Epping to Thornleigh Third Track Proposal. Application number SSI 5132.

I/we object to the Epping to Thornleigh Third Track Proposal and consider that the EIS is inadequate and does not address the full impact of this proposal. It will cause untold damage to the health of residents and to the fabric of the Beecroft Cheltenham Heritage Conservation Area. Do not approve this project, reconsider the alternatives and protect the community.

Figure 5.6 Cross-section and elevation - New Cheltenham Station concourse building
Note: Indicatively added to future design

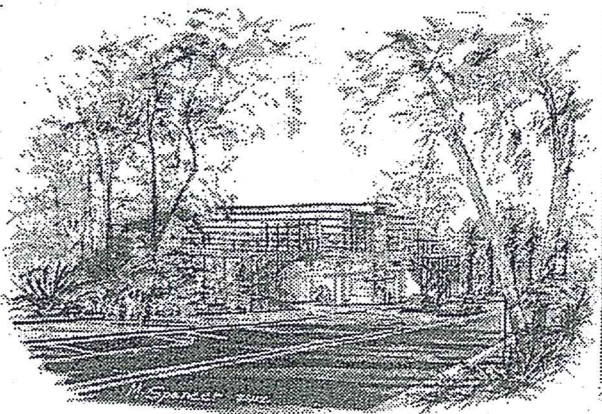
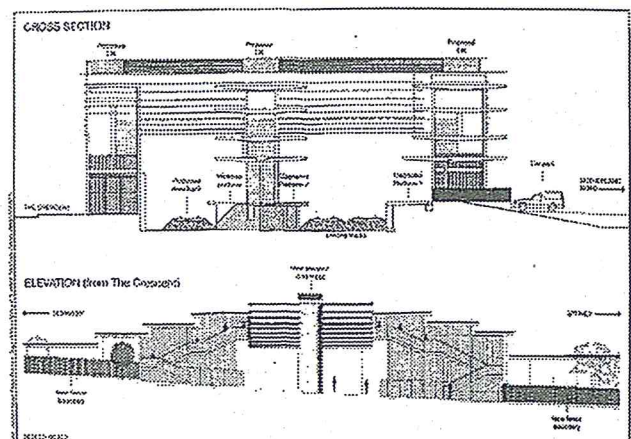
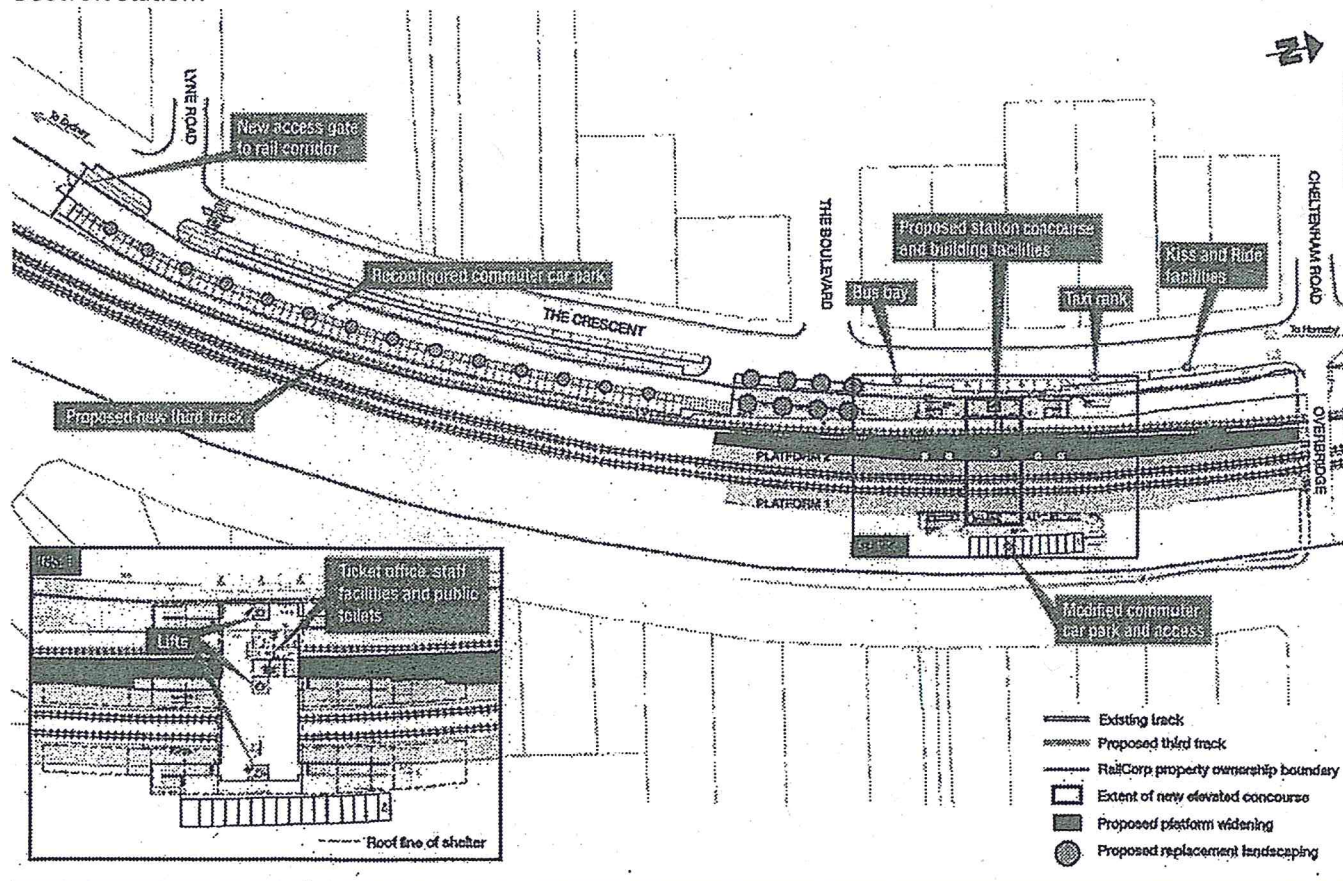
- The proposed redevelopment of Cheltenham Station shows no regard for the HCA. The visual impact of the proposed 13m high glass and steel concourse is totally unacceptable in this HCA.
